**From:** Simon Davis  
**Sent:** 06 November 2025 09:42  
**To:** 'Kate Chapman' [REDACTED]  
**Subject:** RE: Land at West Barn, Old Dairy Lane - AL/107/25/PL

CLIENT BioDot		
PROJECT New office building adjacent to West Barn Norton Lane, Norton, Aldingbourne		
DRAWING TITLE Block Plan and Location Plan		
DATE Feb 2025	SCALE As shown	DRAWN BY
		CHECKED BY
JOB NO. 25 / 01	DRAWING NO. 04	REVISION Rev C

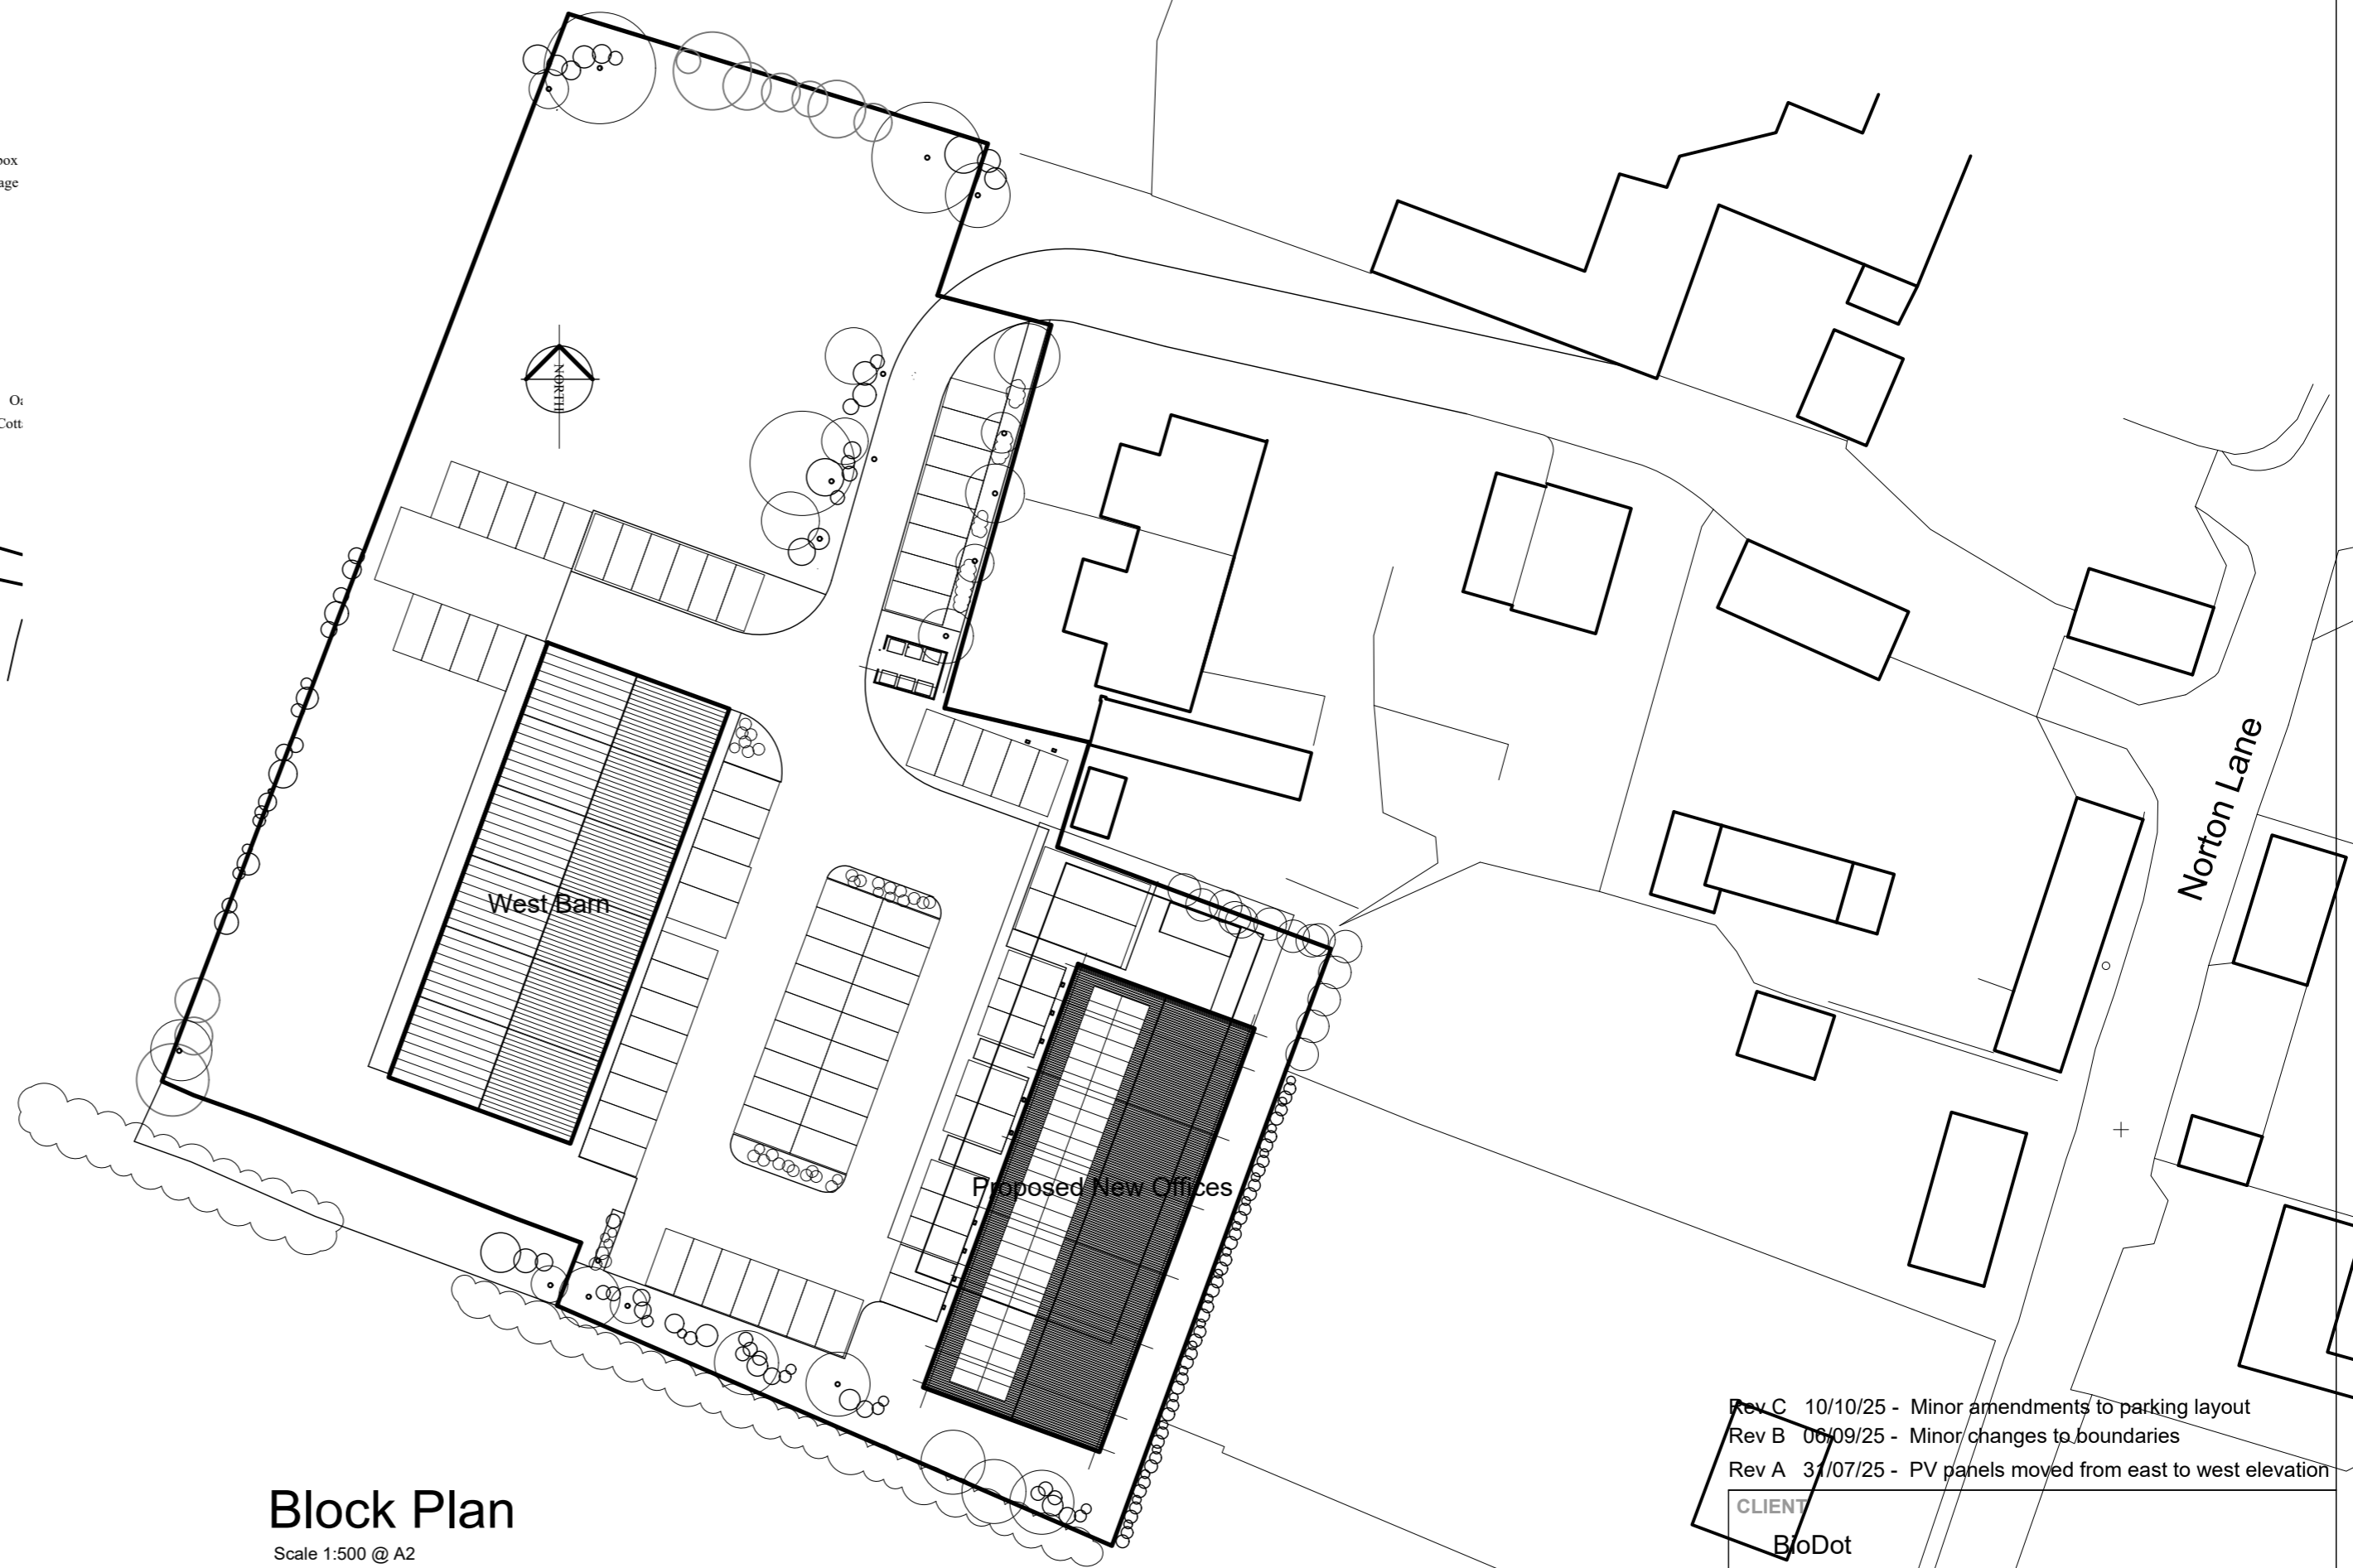
A resident has written to state that the plans are inaccurate as not all nearby buildings are shown. Whilst this was not a validation requirement, I can see that there are differences between our OS mapping and your location and block plan including that a dwelling immediately adj the northern boundary (The Old Stables) is not shown. Also, other dwellings are not drawn to their correct shape. This may affect the assessment of impact on other buildings. I would therefore request that you provide an updated version of the plans please.
